**Planning Department
Transportation Development Services**

**Re: The Carlisle
3600 Central SE
Traffic Circulation Layout**
Engineer's/Architect's Stamp dated 11-11-15 (K17-D069)

Based upon the information provided in your submittal received 11-12-15, the above referenced plan cannot be approved for Building Permit until the following comments are addressed:

COA STAFF: ELECTRONIC SUBMITTAL RECEIVED: _____

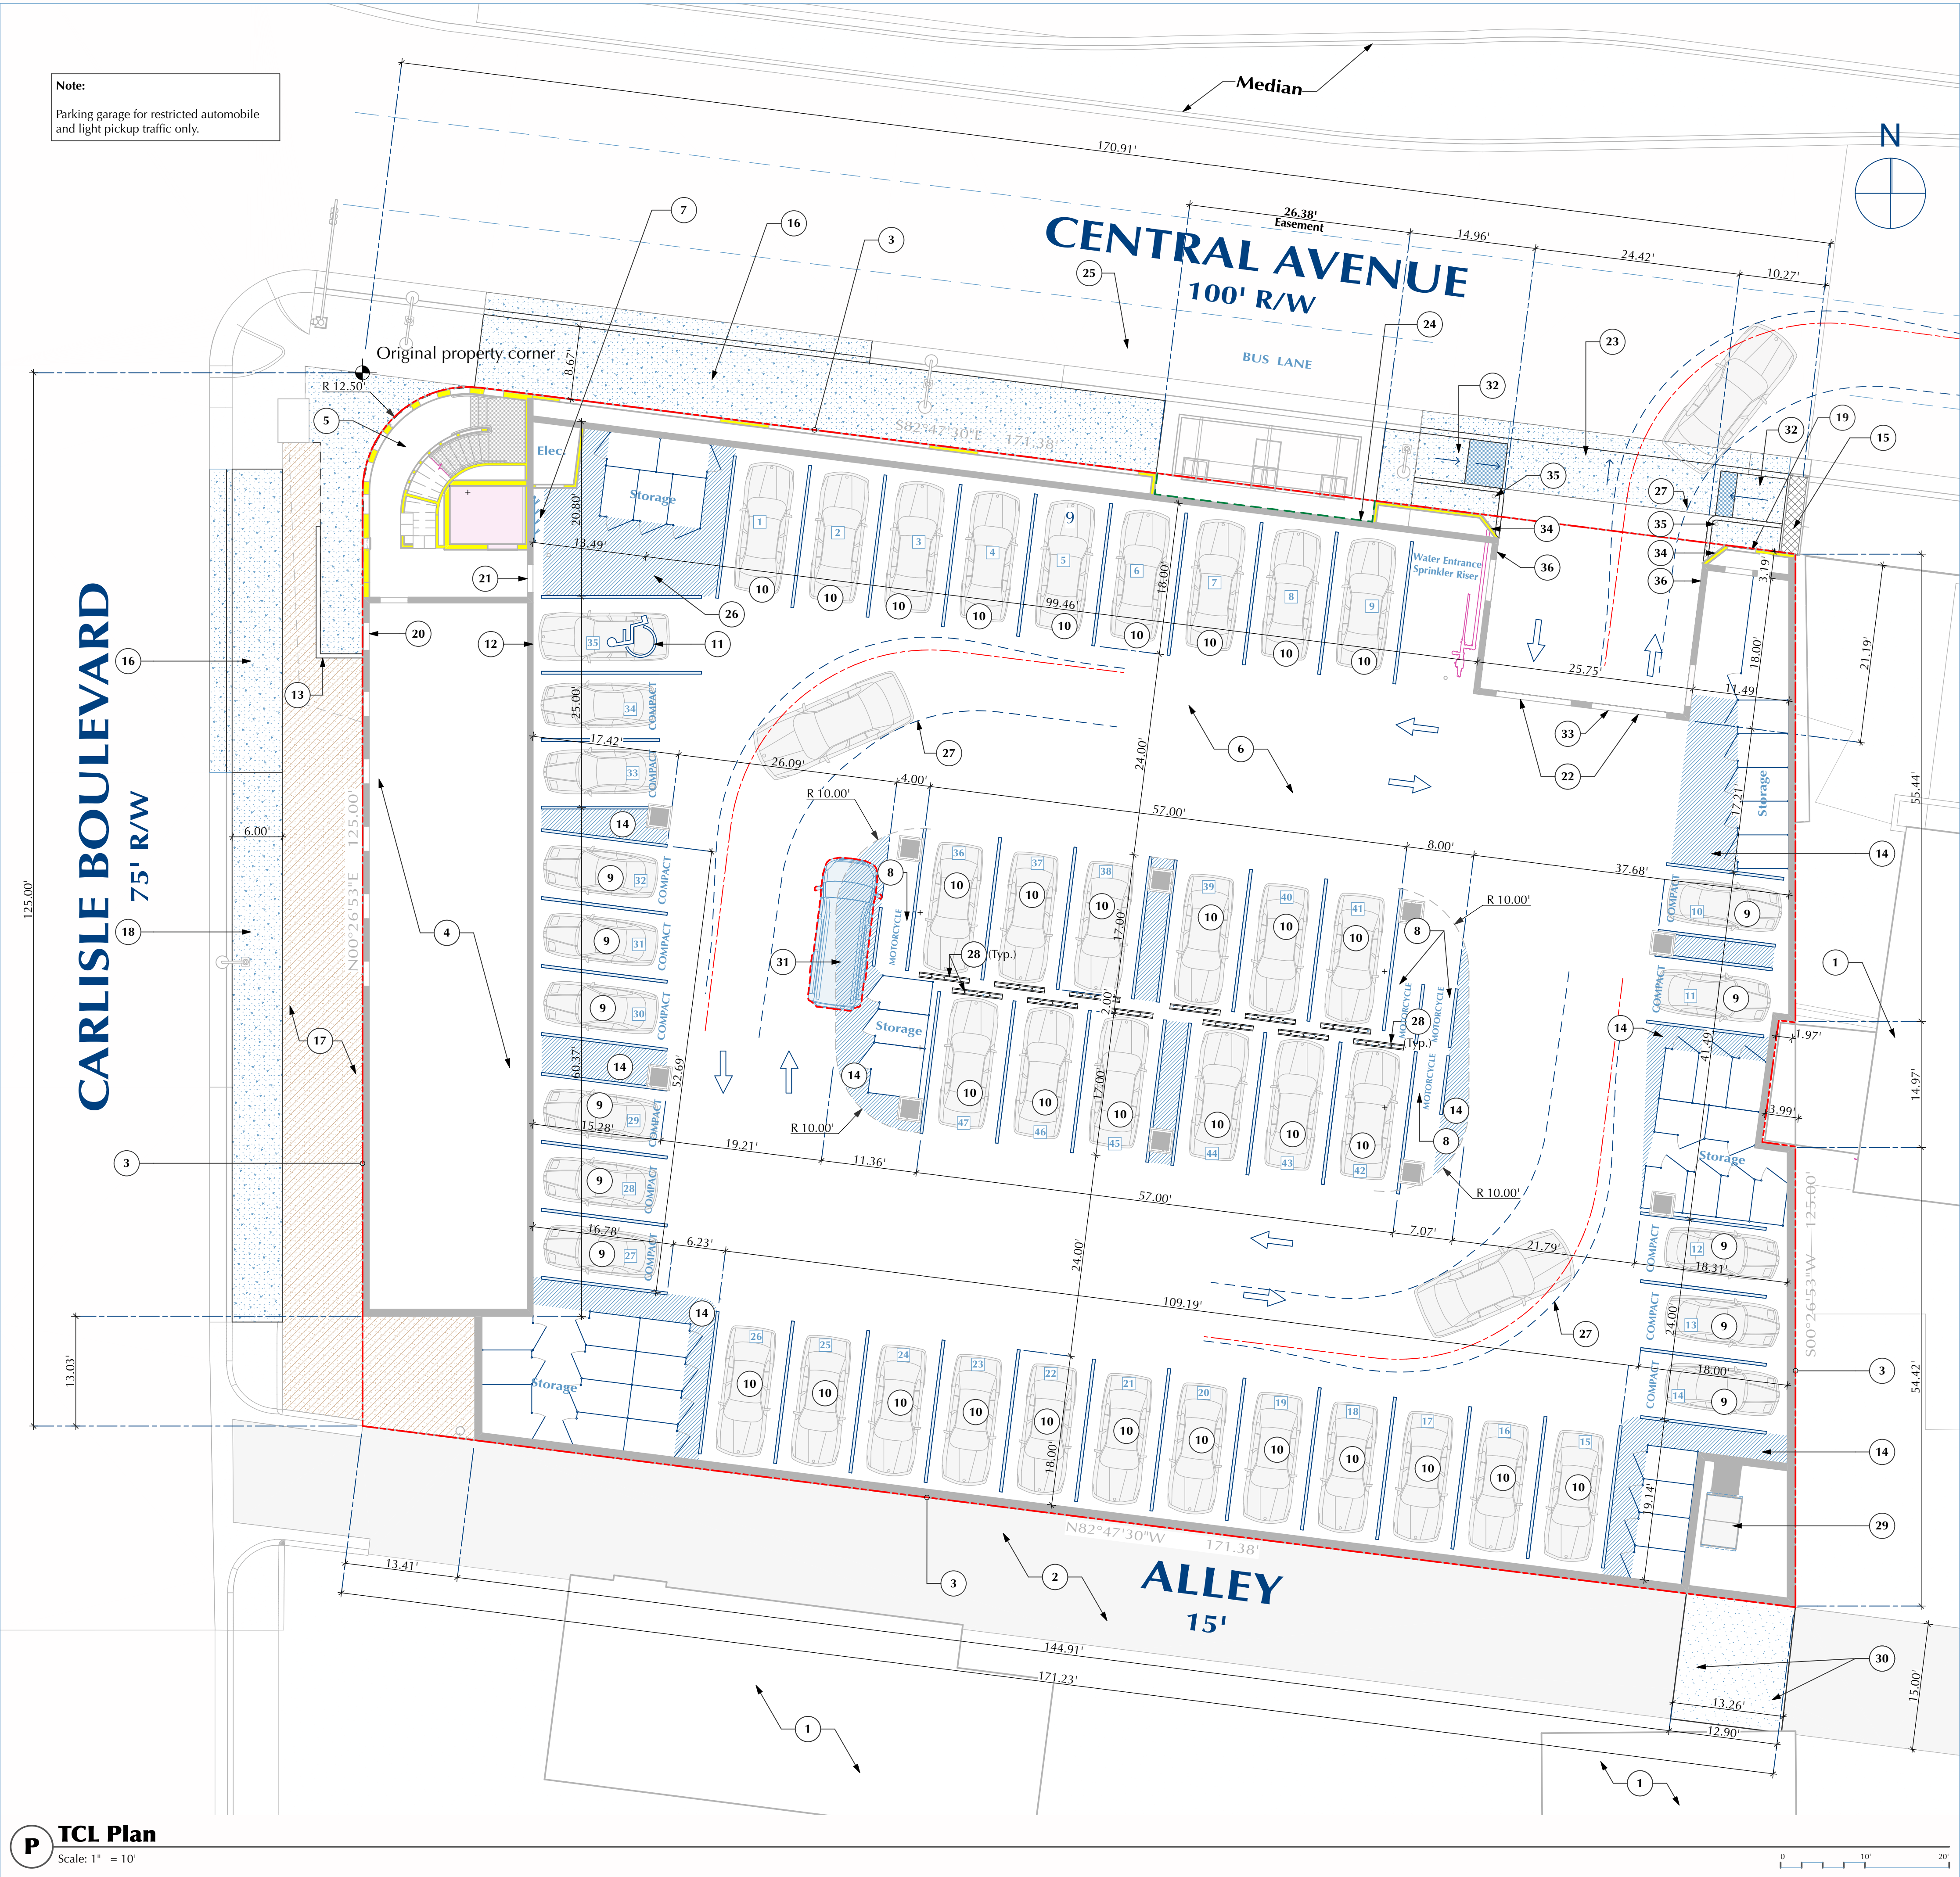
1. Upon review, the development project does not meet the Clear Sight requirements.
2. Please include two copies of the traffic circulation layout at the next submittal.
